City of Portland, Maine - Building or Use Permit Application

Permit No: 09-1359	Issue Date:	CBL: 013 E012001
-----------------------	-------------	---------------------

Past Use: Commercial - connected to permit #09-0275 (see for use)	Proposed Use: Commercial / Install stairs and ramp from 3rd level to ground level to meet egress.	Permit Fee: \$70.00	Cost of Work: \$5,000.00	CEO District: 1
		FIRE DEPT: <input type="checkbox"/> Approved <input type="checkbox"/> Denied	INSPECTION: Use Group: Type:

Third Floor  
Egress Stairway

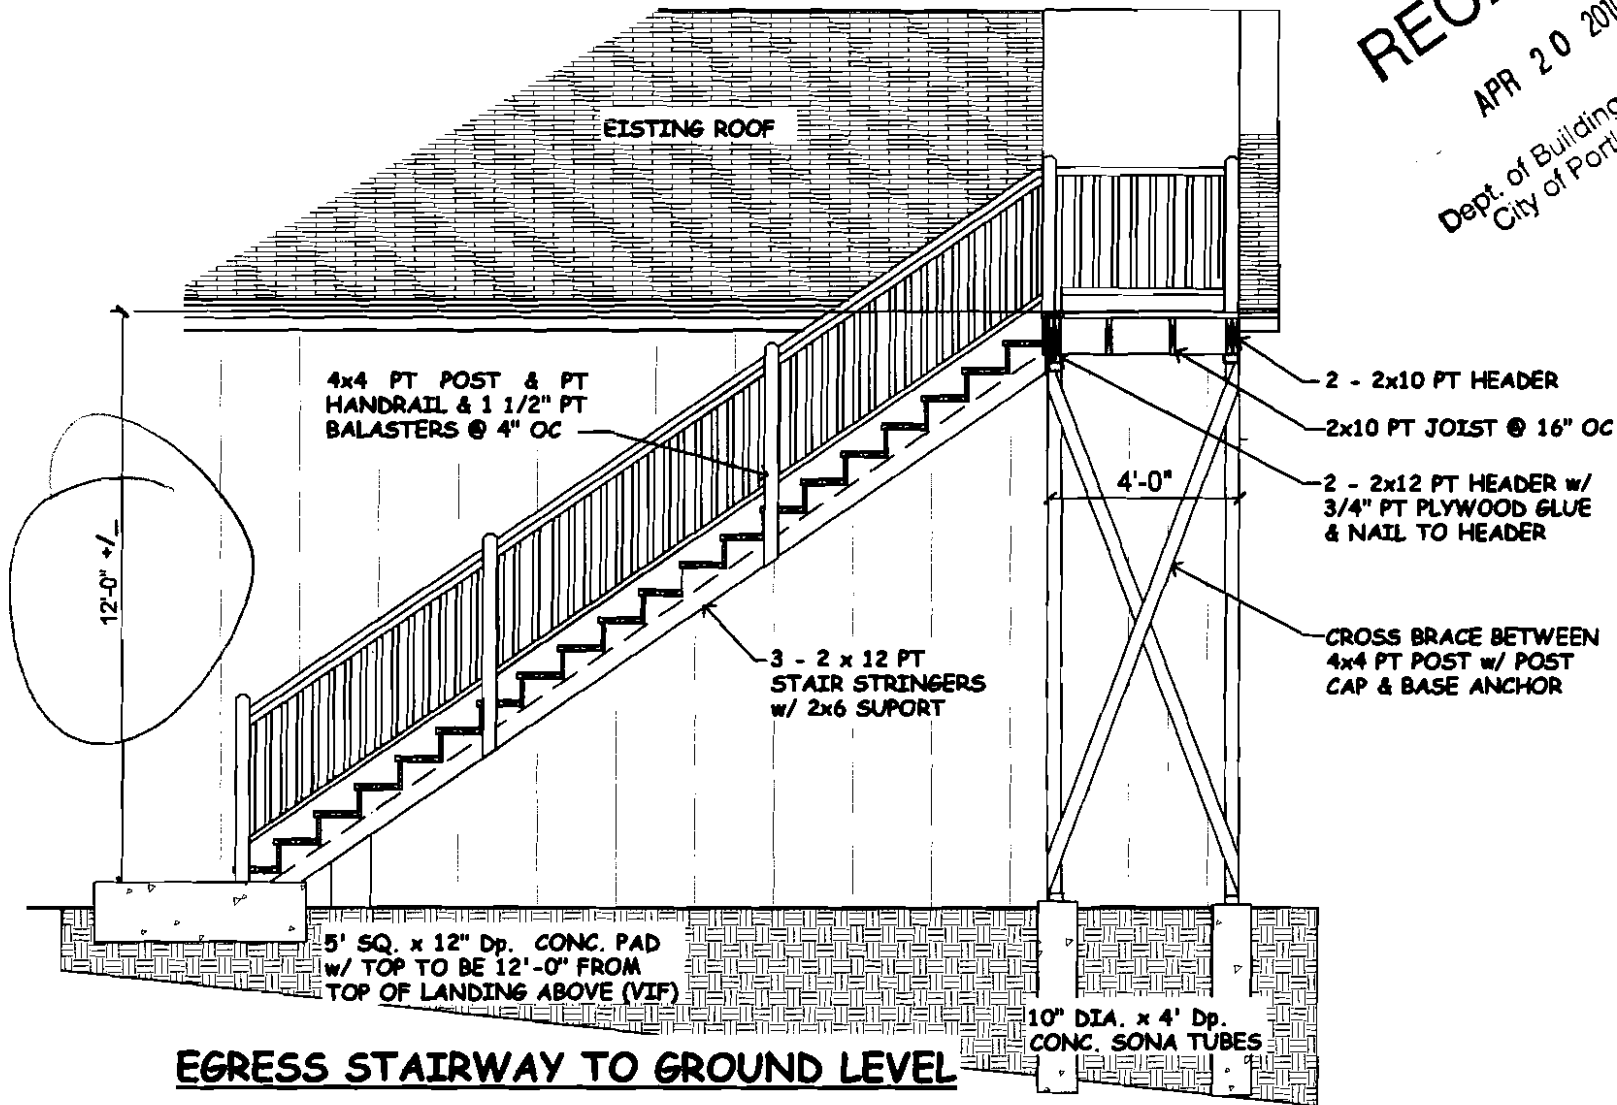
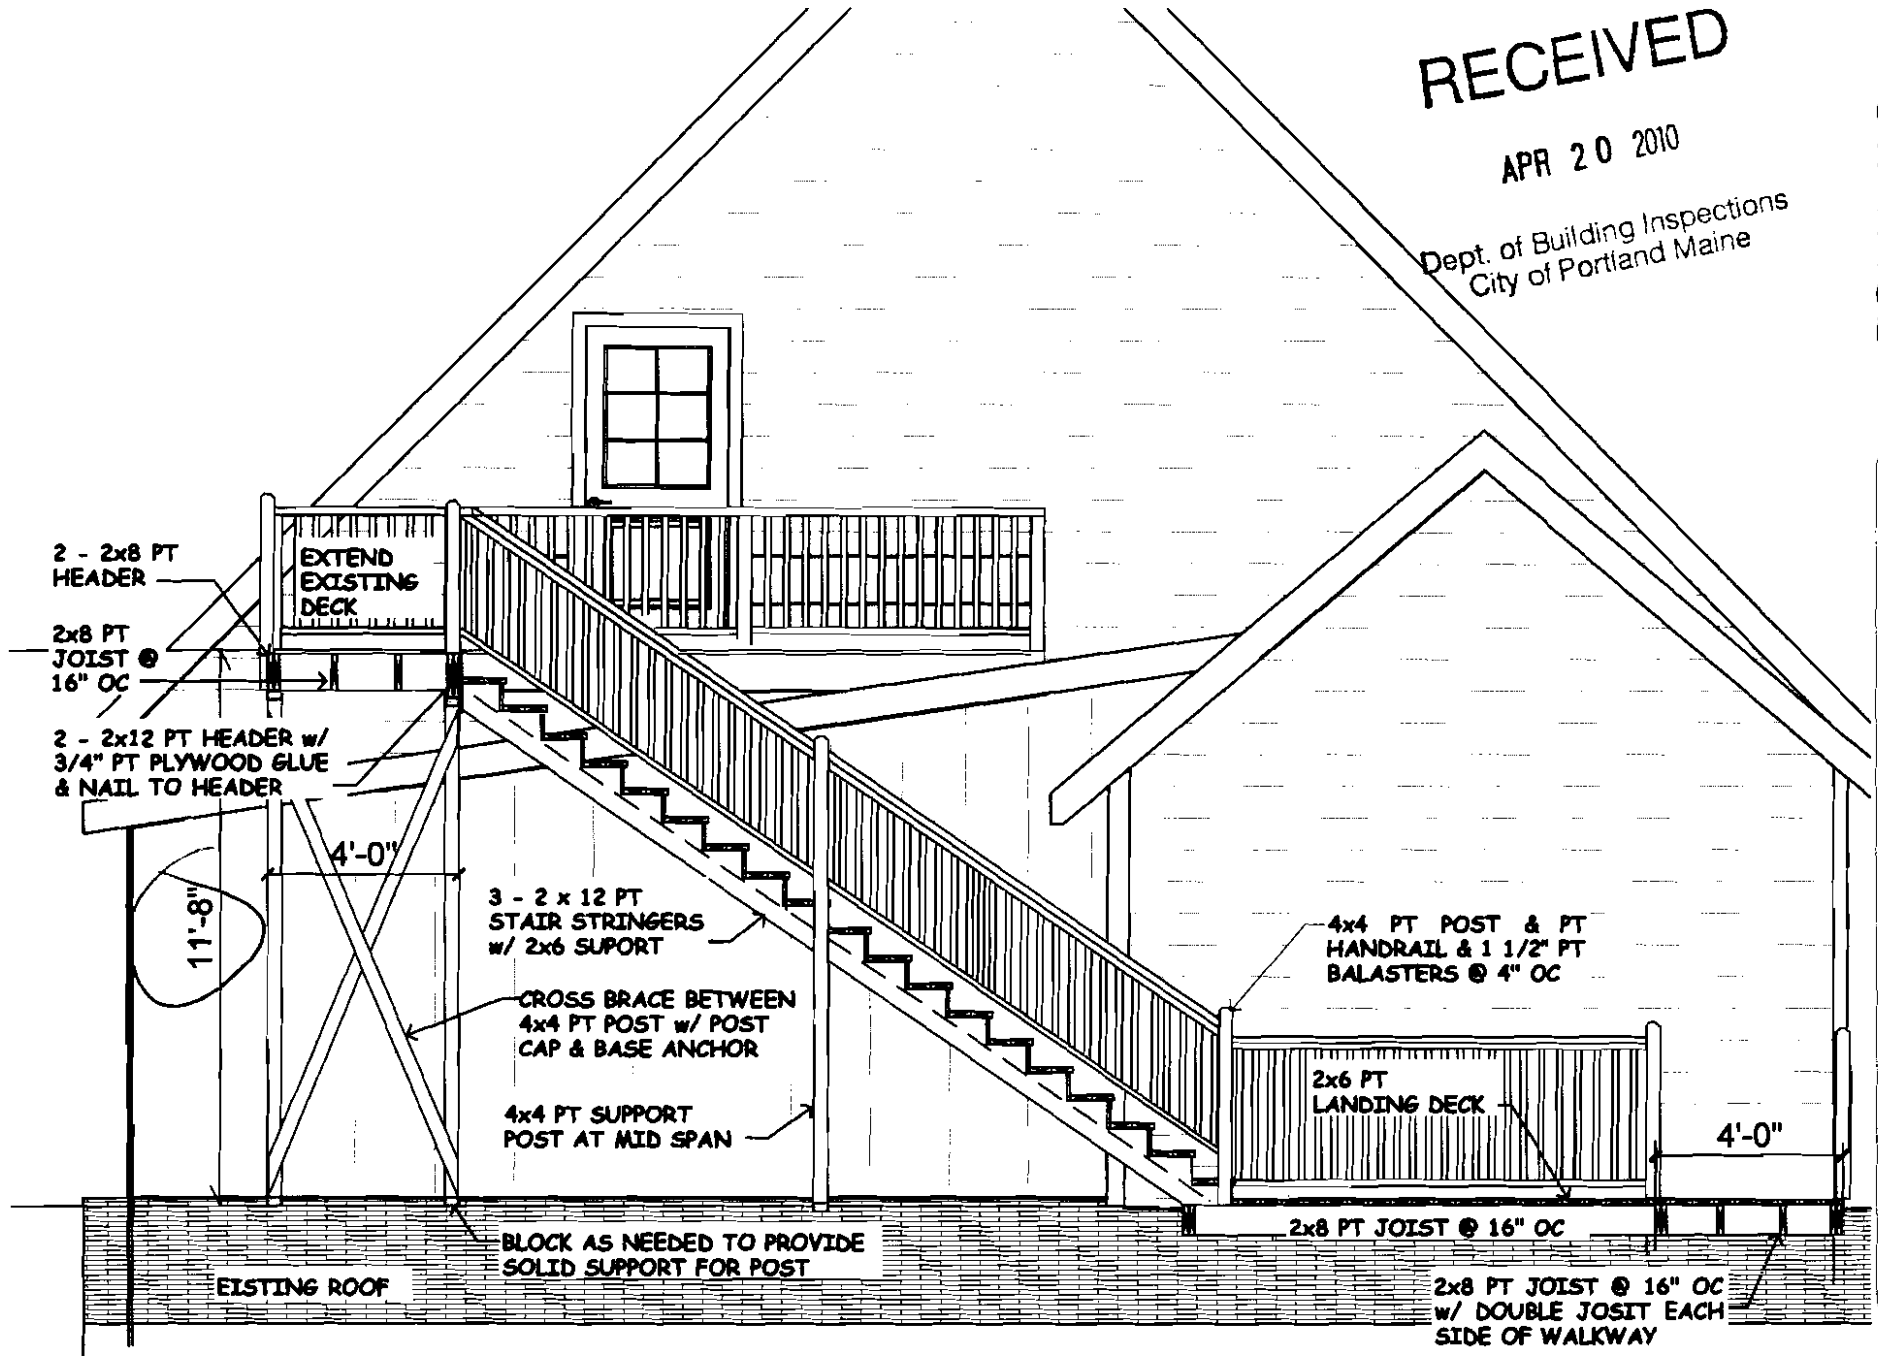
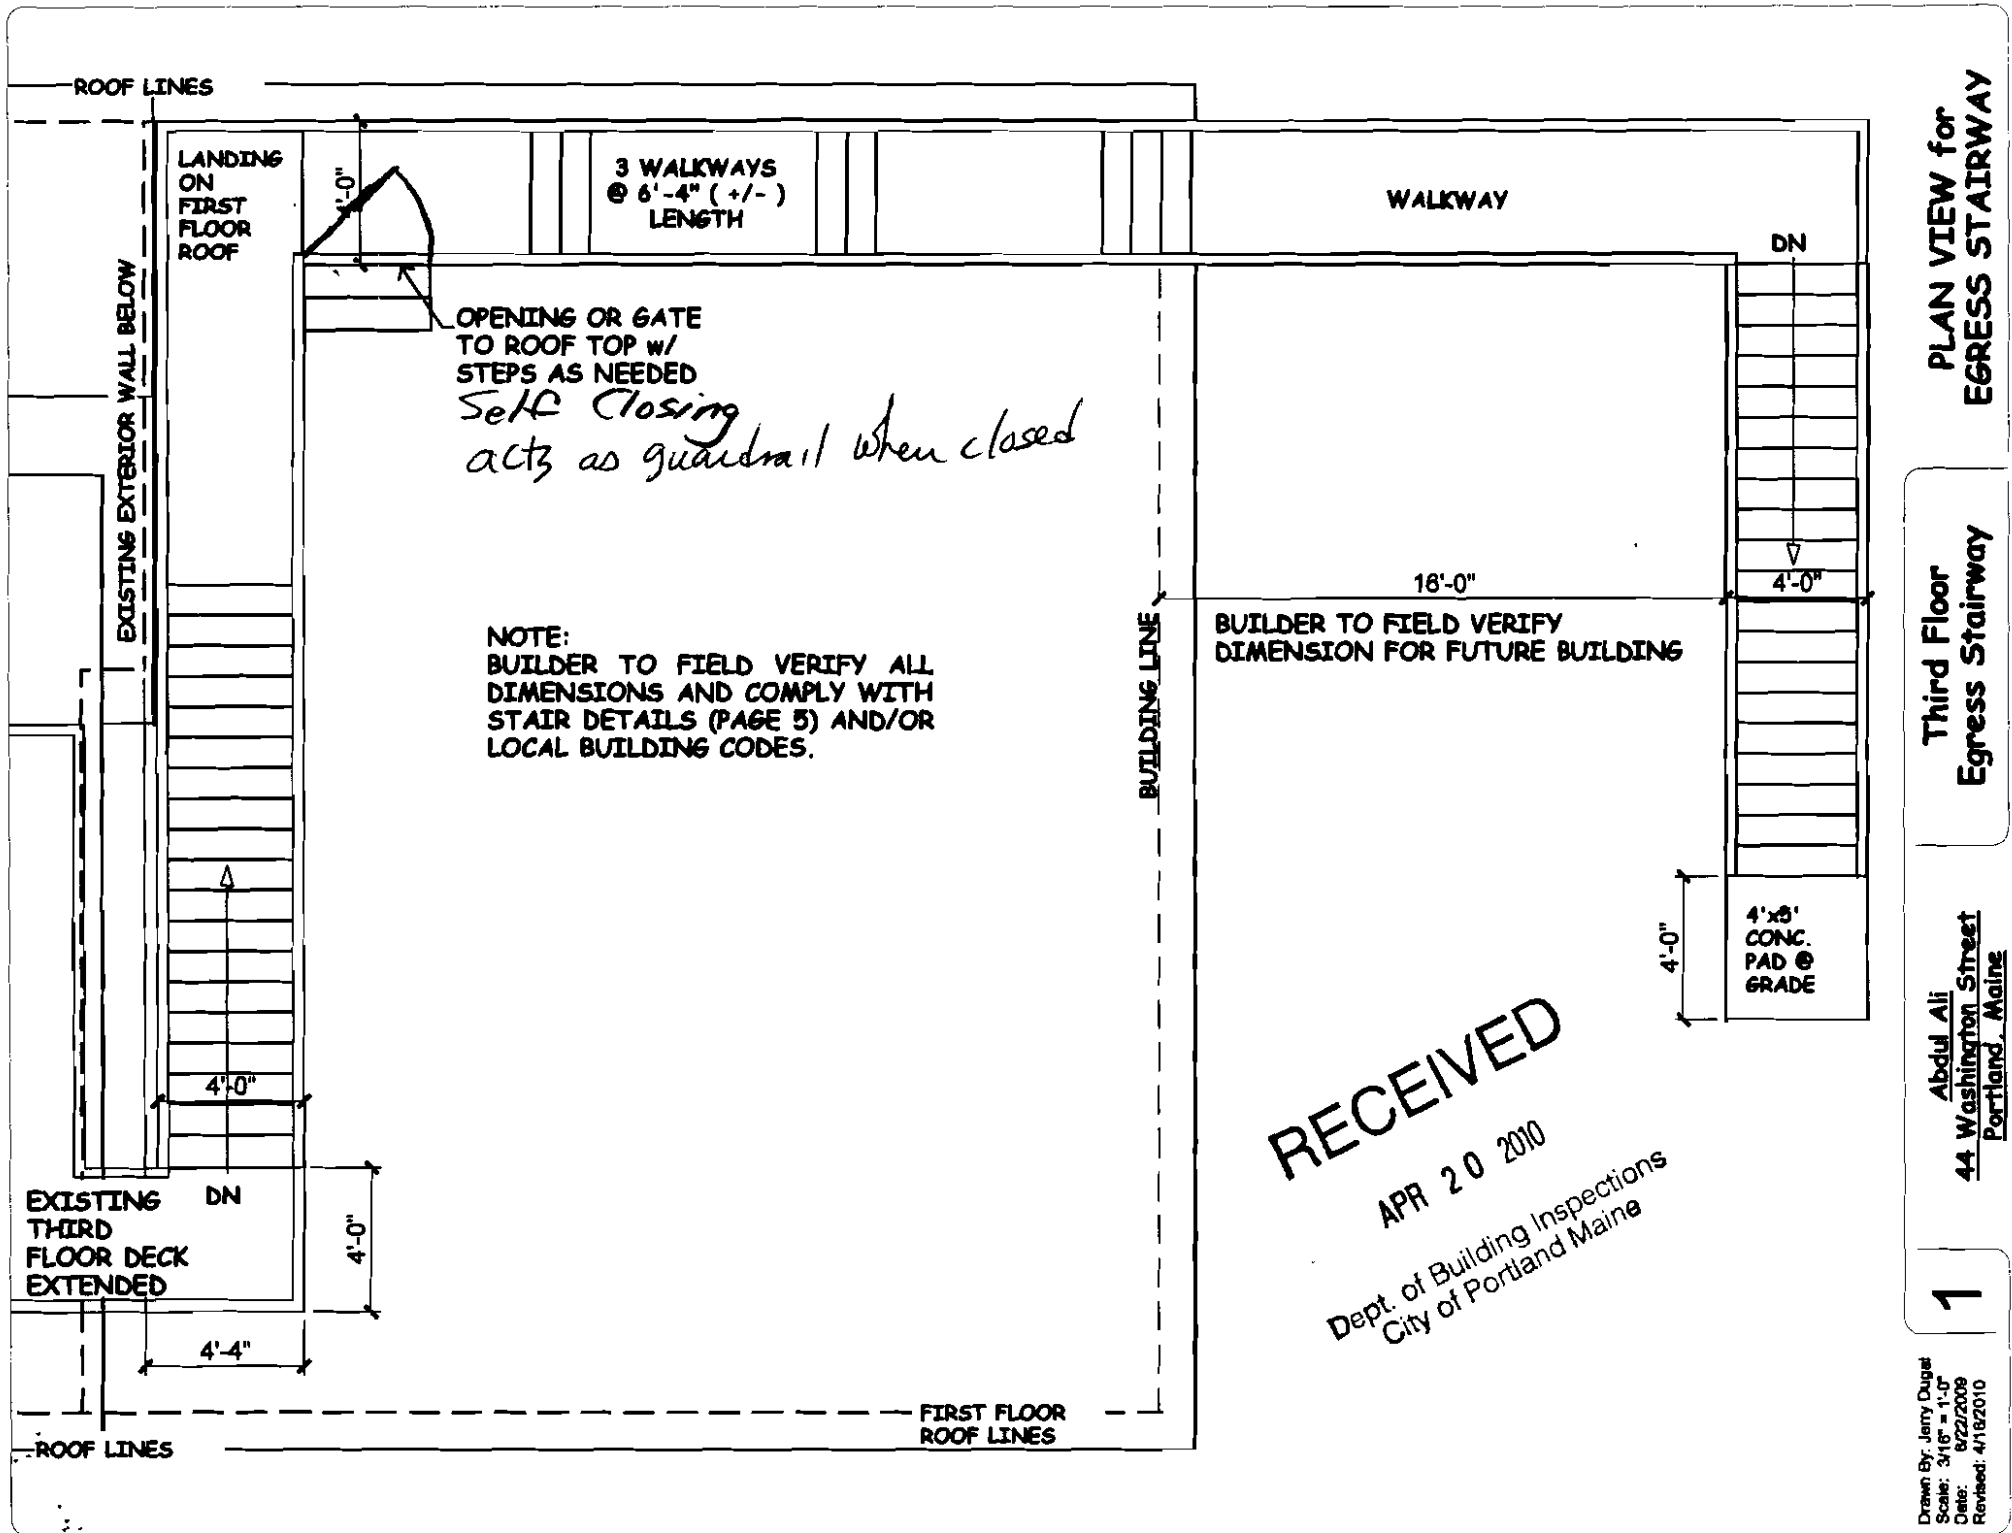
1) Elevation of the final stairs to grade shows 12', if more an intermediate landing will be required			
2) Application approval based upon information provided by applicant, with revisions dated 4/20/10. Any deviation from approved plans requires separate review and approval prior to work.			
Dept: Fire	Status: Approved with Conditions	Reviewer: Capt Keith Gautreau	Approval Date: 04/21/2010
Note:			Ok to Issue: <input checked="" type="checkbox"/>

4/30/2010-jmb: Spoke to Jim M. About the 12' height to grade, he thinks it is less, but will notify if more and may have to do an intermediate landing, ok to issue
